Engineers Comments Regarding Surface Water Drainage

Application Reference:	LU/141/25/PL	Reviewer Reference:	ADC/EXT5/AF
Planning Officer:	Miss K Welch	Date of Review:	17/11/2025
Site Name:	57 River Road Littlehampton BN17 5DD		
Application Description:	Partial demolition of number 57 River Road, change of use & re-development to provide a flatted development comprising 9 No. apartments with private amenity space, parking & cycle storage, including the partial demolition of the adjacent boundary wall to provide a new pedestrian access & the creation of a floating pontoon with resident morning spaces (resubmission following LU/251/21/PL). This application affects the character & appearance of the Littlehampton River Road Conservation Area & is in CIL Zone 4 (Zero Rated) as flats.		
Assessment Number:	1

Proposed Drawings

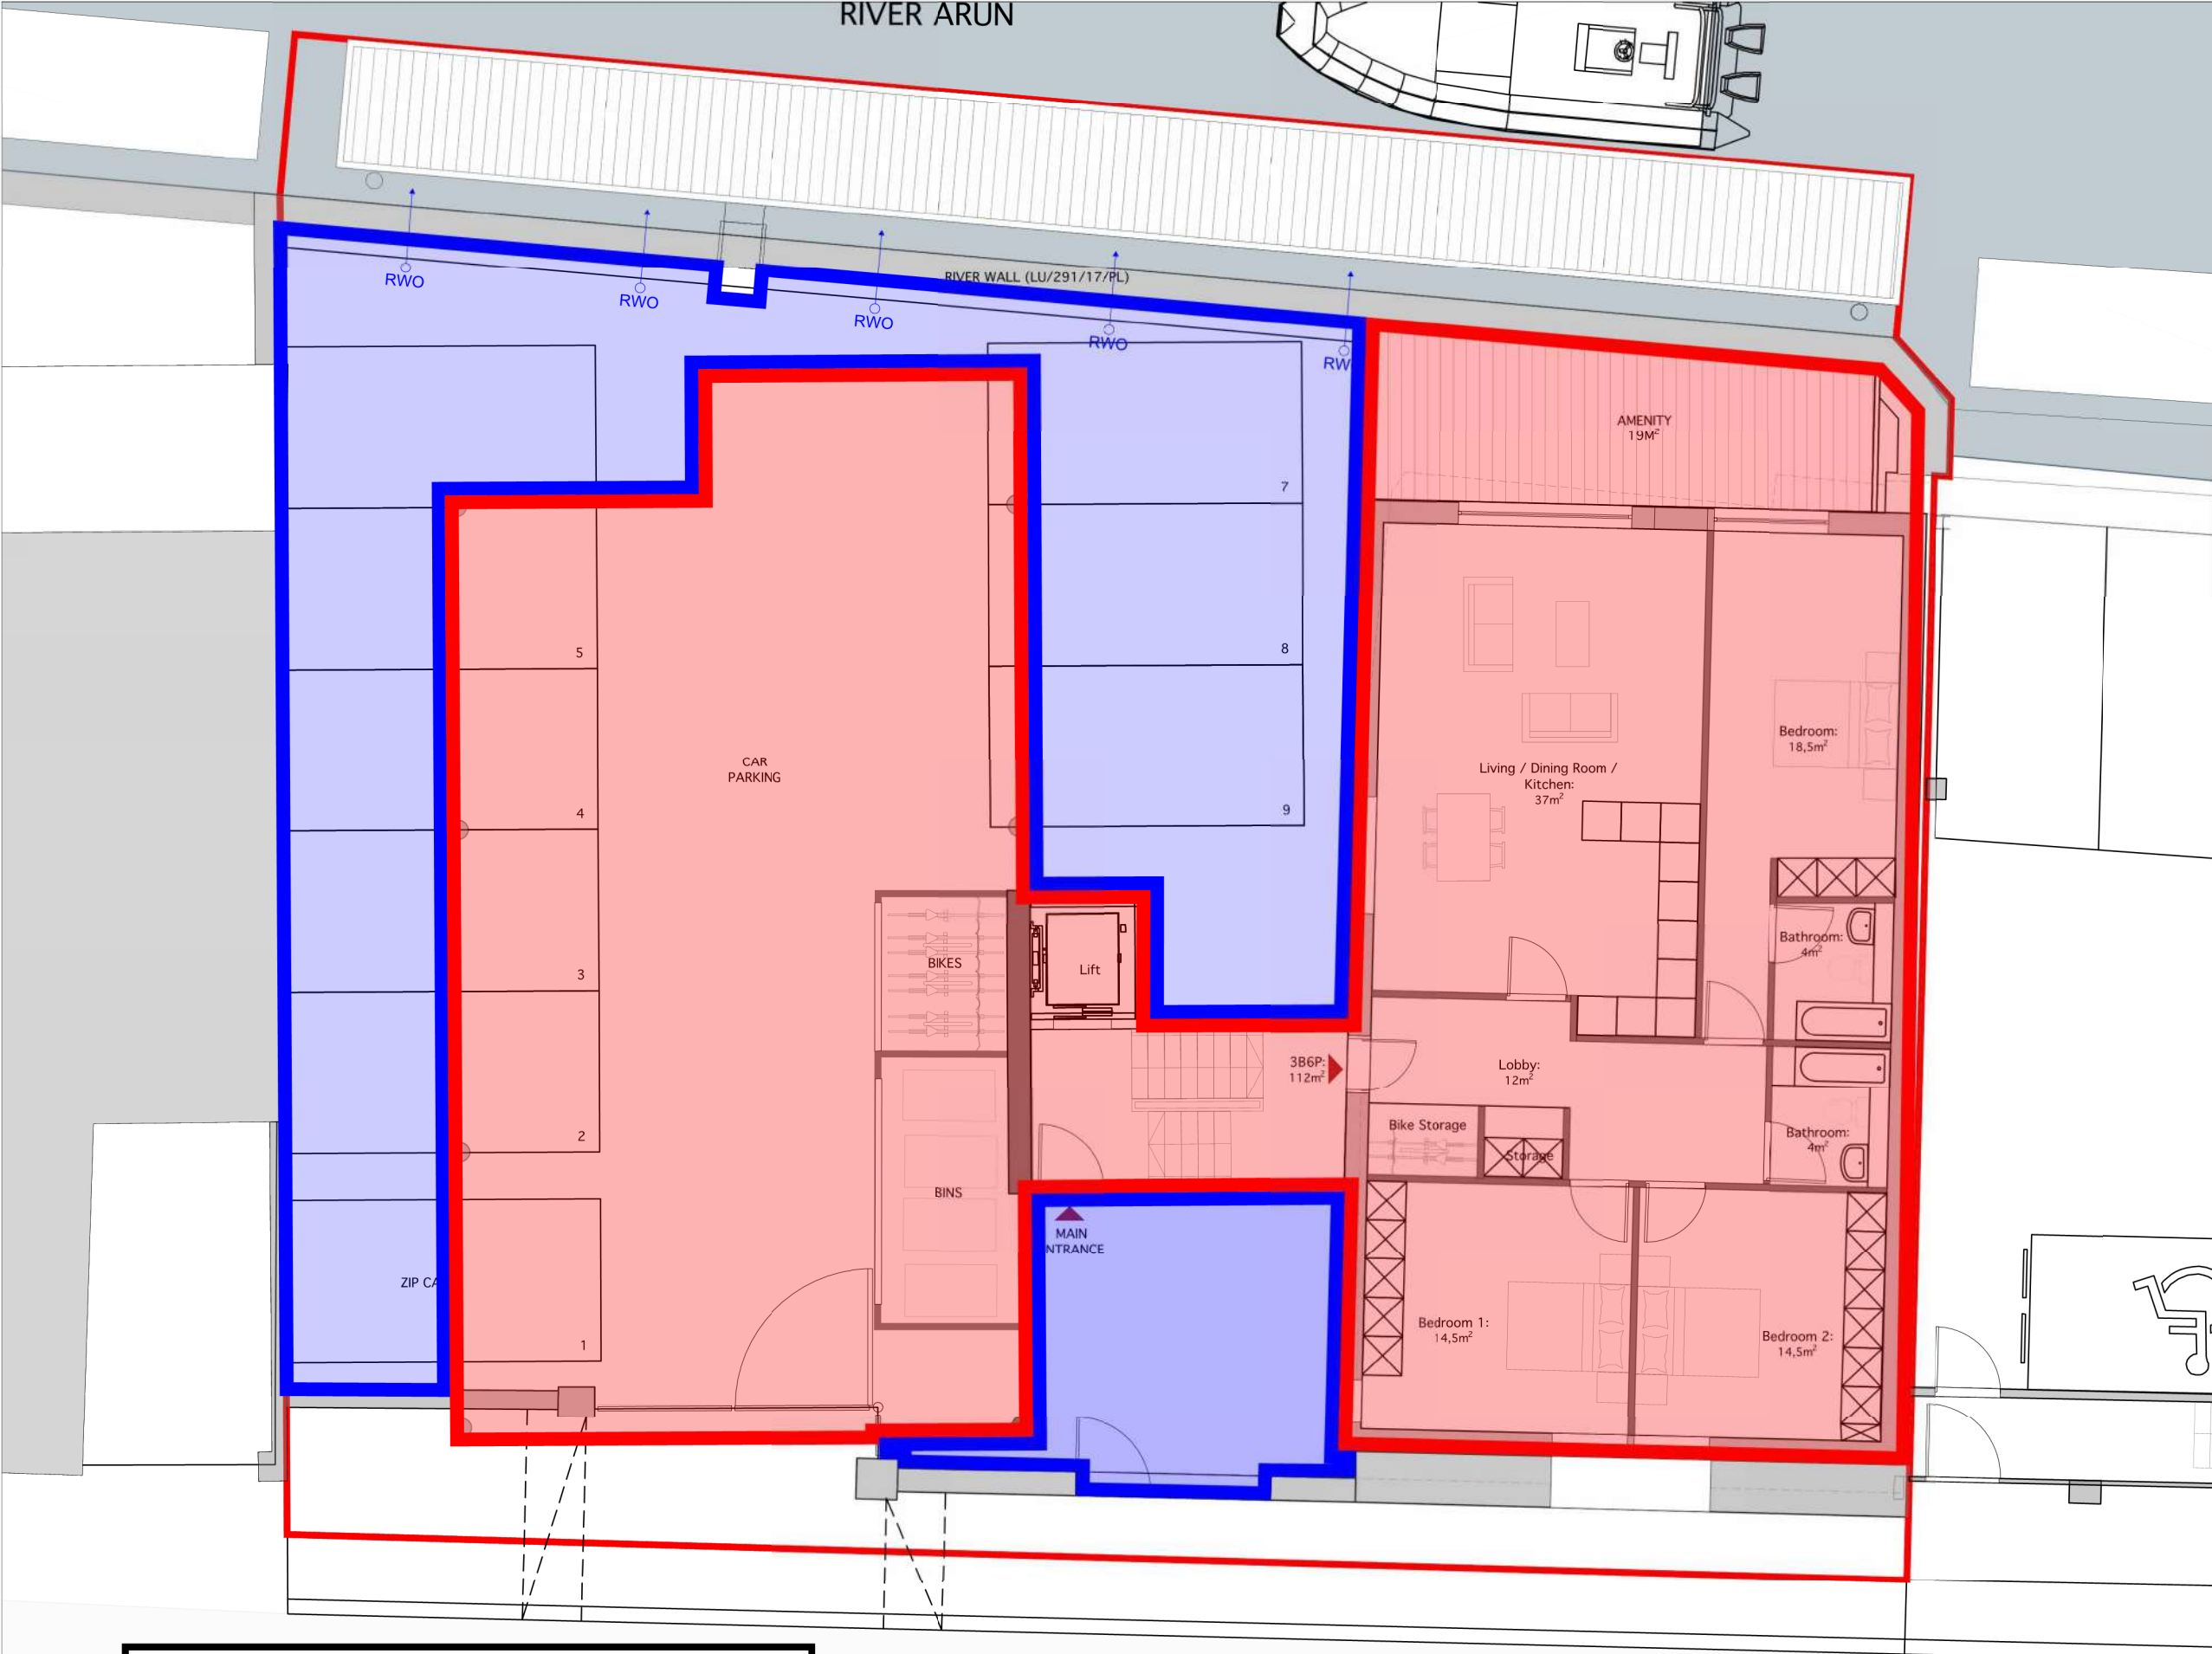
- 2.1. The opportunities for interception drainage include lined permeable paving and green roofs or walls, or other method to be proposed by the applicant. The drainage assessment states that there is no external paved area available to locate permeable paving but this does not appear to be the case from the submitted plans as there is a ground floor level car park.

- 3.1. The drainage strategy is to attenuate large return period storms within a below ground storage tank with a restricted outlet to a sewer for the roof area, and the external areas to discharge to the River Arun without restriction.
- 3.2. The design shown in the drainage assessment is a concept level mark-up of the site plan and not an engineering design with sufficient information for full planning stage.
- 3.3. There are a number of deficiencies in the drainage calculations when reviewed against current SuDS standards and guidance and the Arun DC drainage checklist, set out below.
- 3.4. The CV values are set to 0.95 and should be 1.0.

- 3.8. The drainage strategy plan states the flow control is 1.7 litres per second, whereas the 100 year greenfield runoff rate for the site is stated as 0.29 litres per second. It is our view that the development proposals and assessment has not demonstrated that the sustainable drainage system cannot achieve close to greenfield runoff rates. A relaxation factor can be agreed in accordance with the NSfS (para 3.21) which should be no greater than 5 times GFR for the 50% AEP and 1% AEP storms. However, the development may be able to achieve rates of 0.5 - 1.0 litres per second depending on the design solution. The design should then incorporate measures to reduce the risk of blockage of the flow control device. Please note the requirement for flow control would not apply to direct discharges to the tidal main river, see below.
